Gatwick Northern Runway Project: Air Quality Written Representation Deadline 8

Client: CAGNE

Reference: APS_S1043A_A3-2

Date Published: 7 August 2024

Diagram 3.3.9: Model performance before and after adjustment, London zone

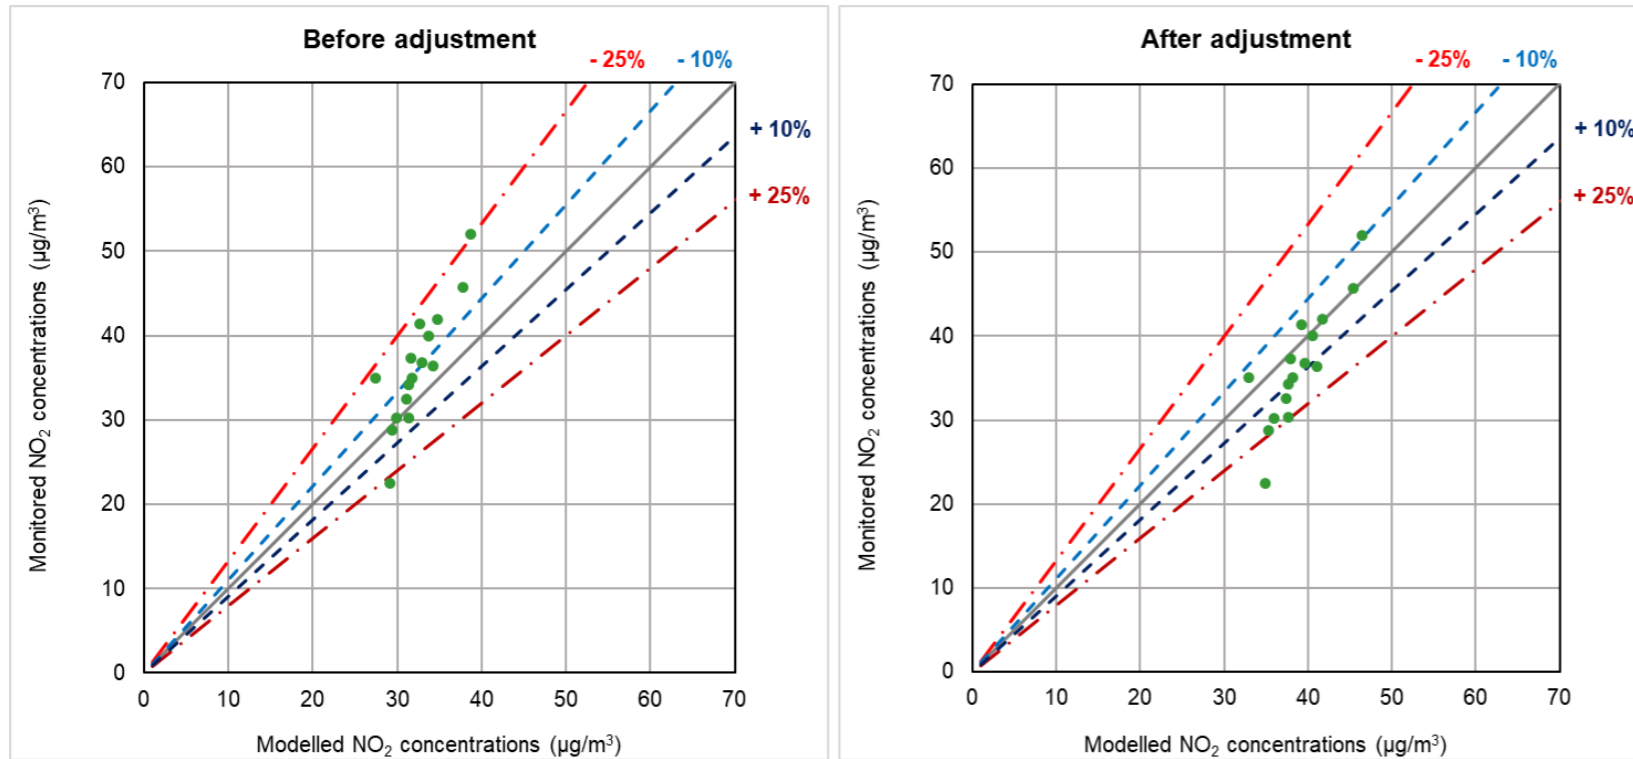
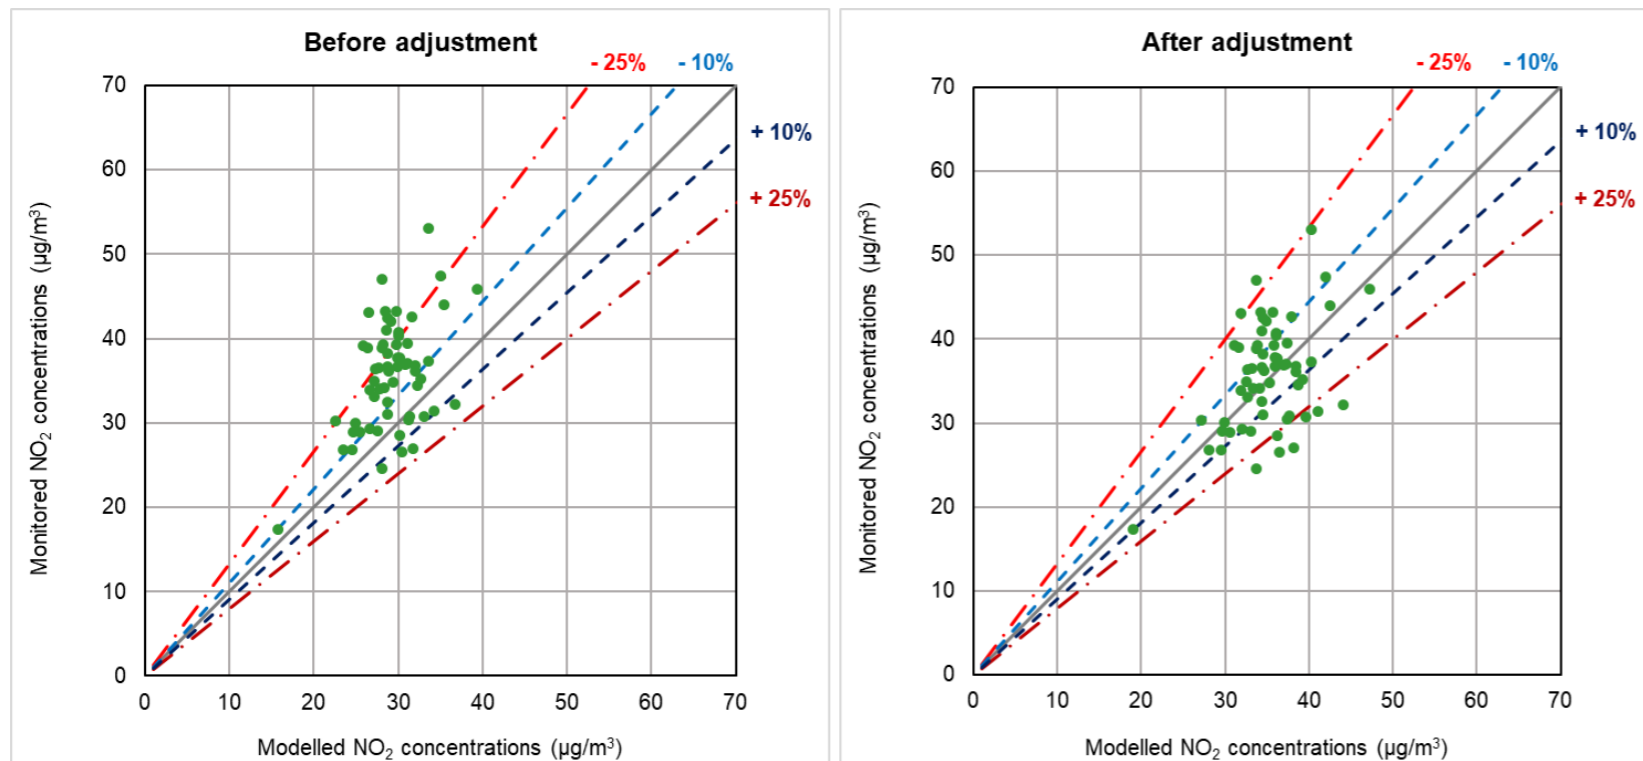
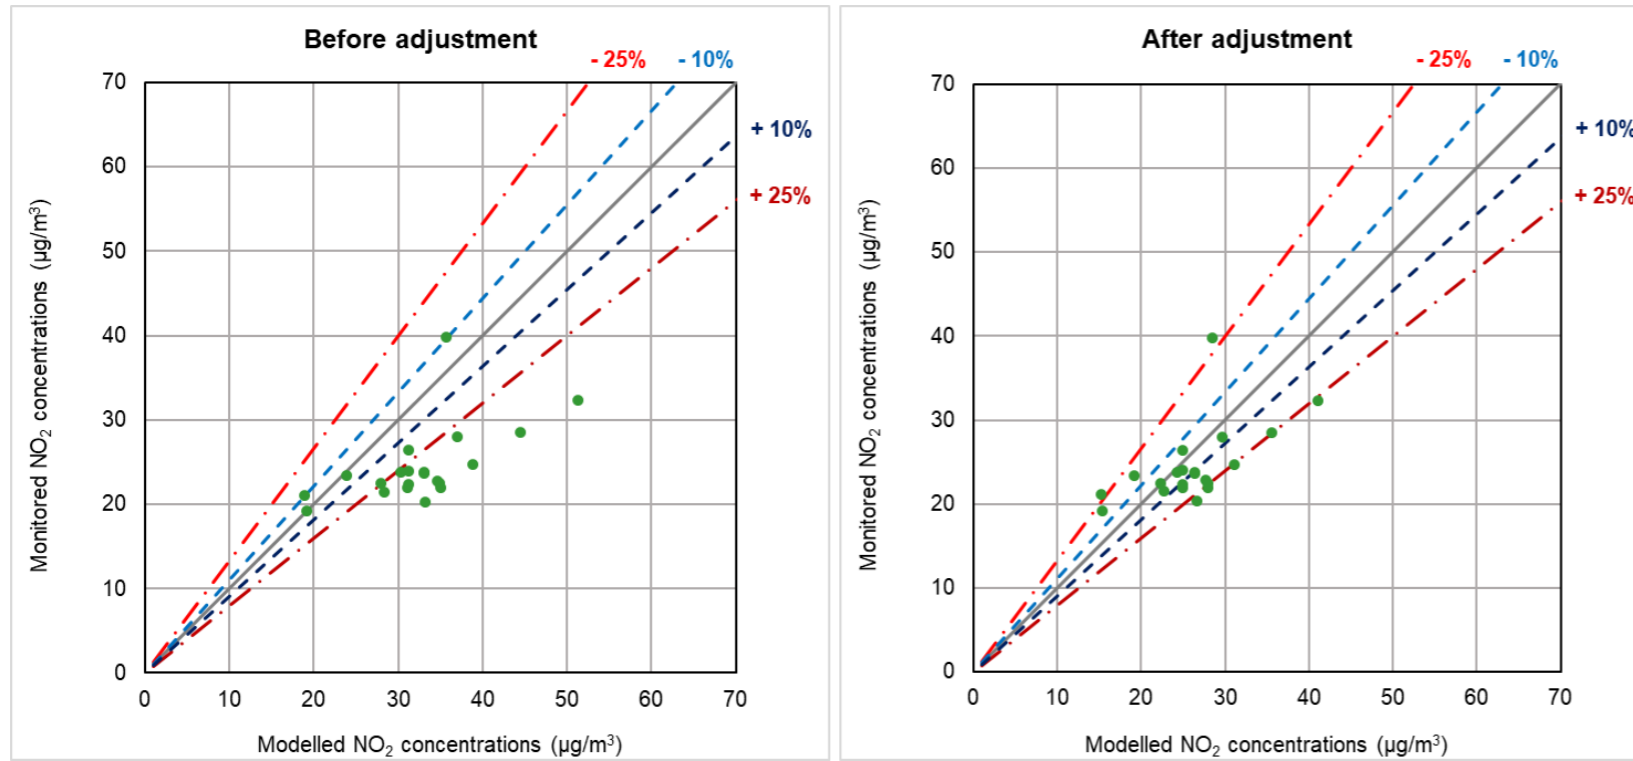
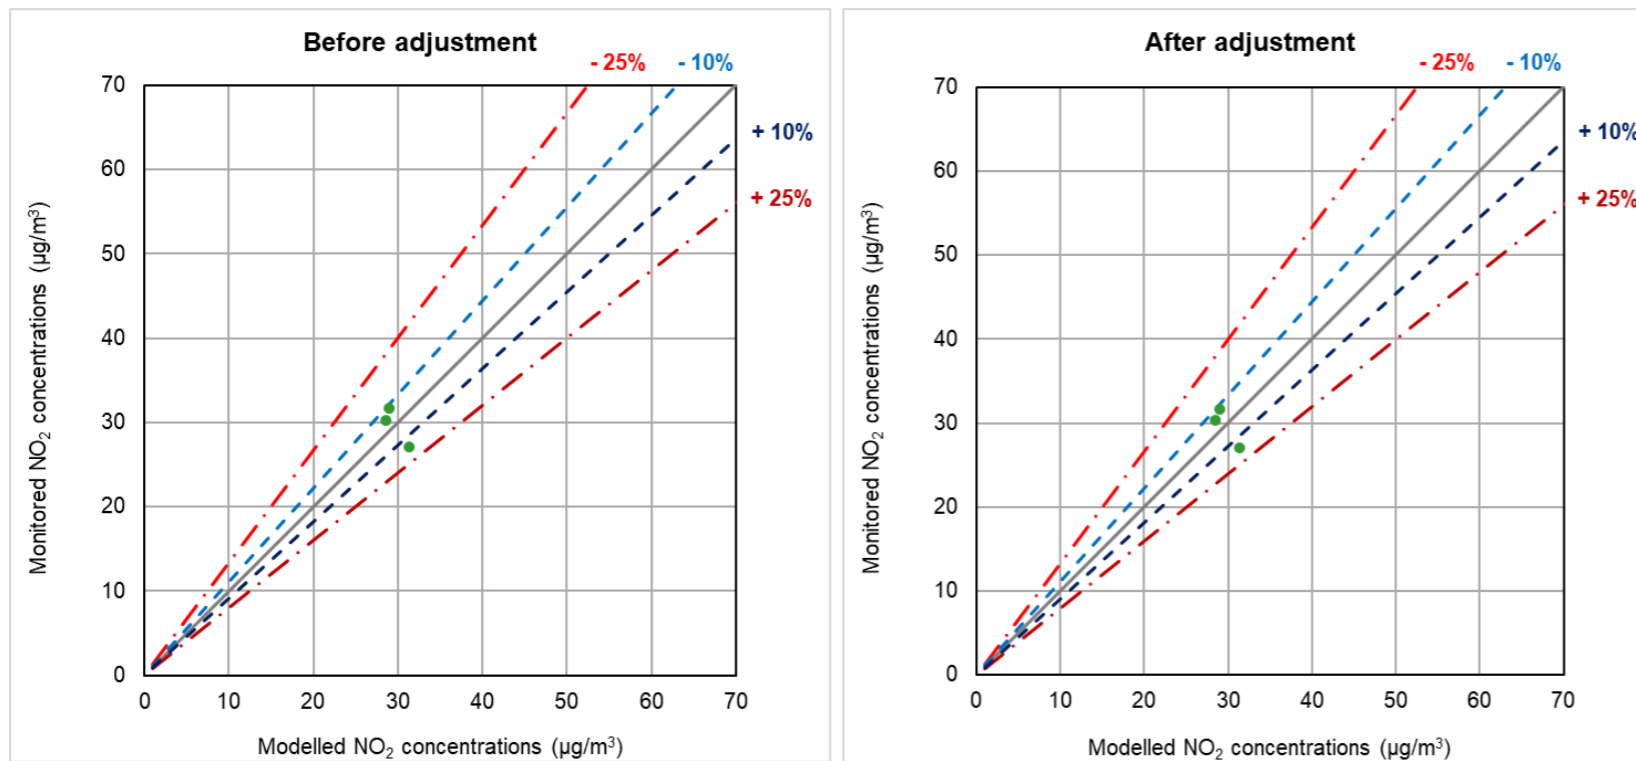
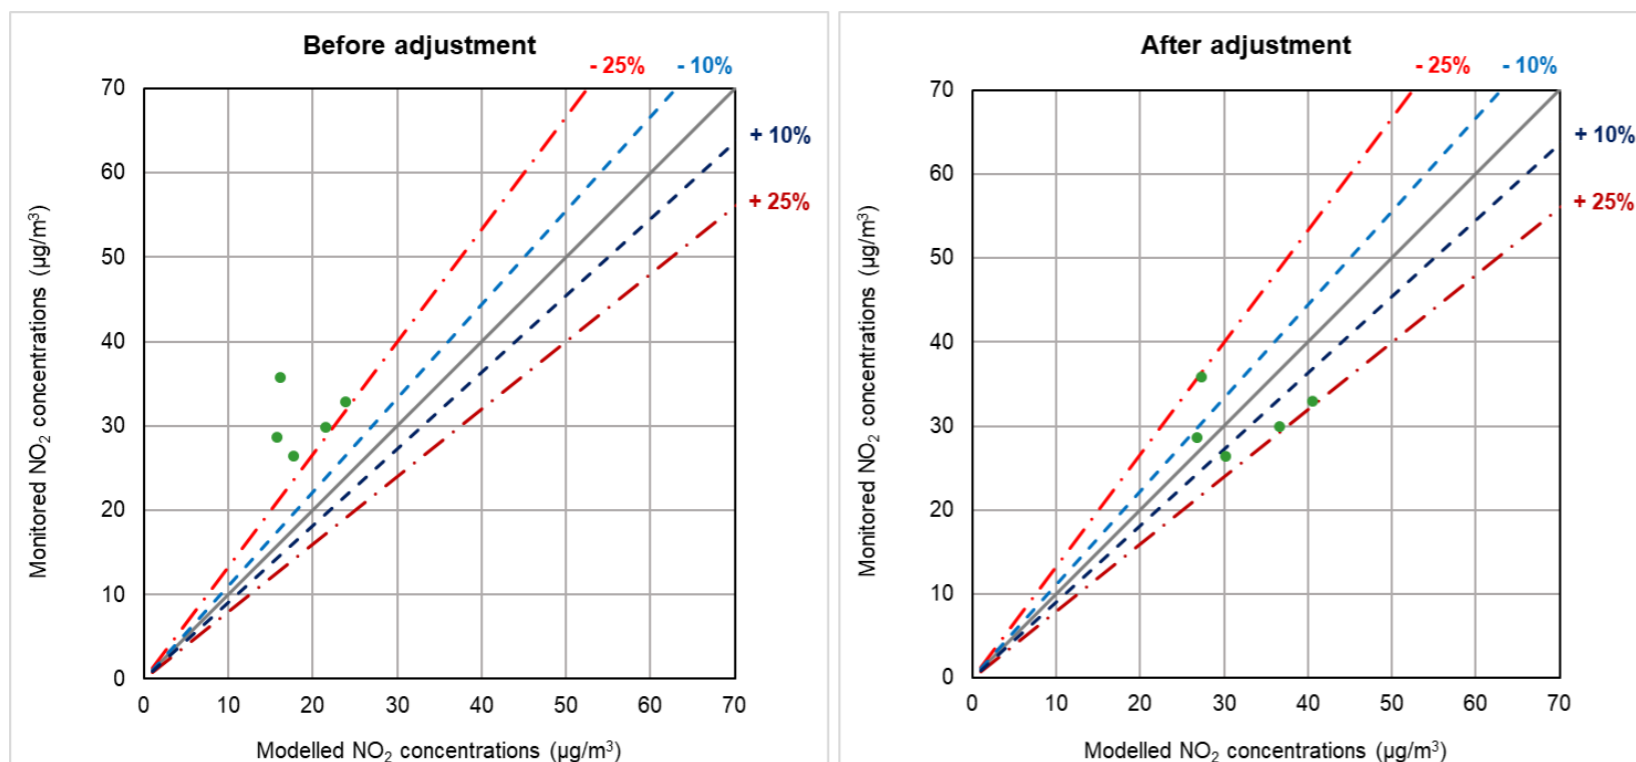
2.15. Section 5 of the GAL response provides a sensitivity test for the road transport emission model for 2032. Paragraph 5.2.14 states:

"The RMSE values are within $\pm 25\%$ of the objective being assessed. The annual mean objective for NO_2 is $40\mu\text{g}/\text{m}^3$, and the RMSE for all zones are lower than $10\mu\text{g}/\text{m}^3$, which is in line with the criteria outlined in section 7.585 of Defra's TG22."

2.17. These statements are incorrect because the paragraph in TG22 states (paragraph 7.585, APS emphasis):

"Ideally an RMSE within 10% of the air quality objective would be derived, which equates to $4\mu\text{g}/\text{m}^3$ for the annual average NO_2 objective."

2.18. Stating that the RMSE is within $\pm 25\%$ does not provide evidence that the model is performing well. It may be acceptable if the uncertainty is numerically taken into account during the assessment of the significance of the predicting effects, which is not the case.

2.19. Paragraph 5.2.7 of the GAL response states regarding the sensitivity test undertaken:

"It shows that the use of one factor across the whole study area would reduce the accuracy of the results compared with the approach used in the ES assessment. This is demonstrated by the number of sites that are within $\pm 25\%$ after adjustment, as well as the statistical parameters used to evaluate model performance."

2.20. In fact, what both the single adjustment and the zonal adjustment factors demonstrate is that at locations where there is no monitoring (i.e. the modelled receptors), there is large uncertainty in the predicted concentrations. As the Applicant is unable to provide individual justification for each zonal adjustment factor (i.e. there is no explanation of why the adjustment factor should be different in each zone; the ES only quotes generic reasons for differences) it is not possible to determine whether that approach is better or worse for predicting concentrations at the receptors than the use of a generic adjustment factor. What is worrying is that the model using the zonal adjustment factors failed to estimate concentrations at the monitoring sites within 10% of the measured concentration at over half the monitoring sites. The application of a zonal adjustment factor to a particular receptor is not justified and there are many examples of close receptors allocated to different zones for no apparent reasons (see Figures 20 to 36 in *Gatwick Northern Runway Project: Air Quality Written Representation Deadline 4*). This is lack of specific justification for the zones adopted s unacceptable.
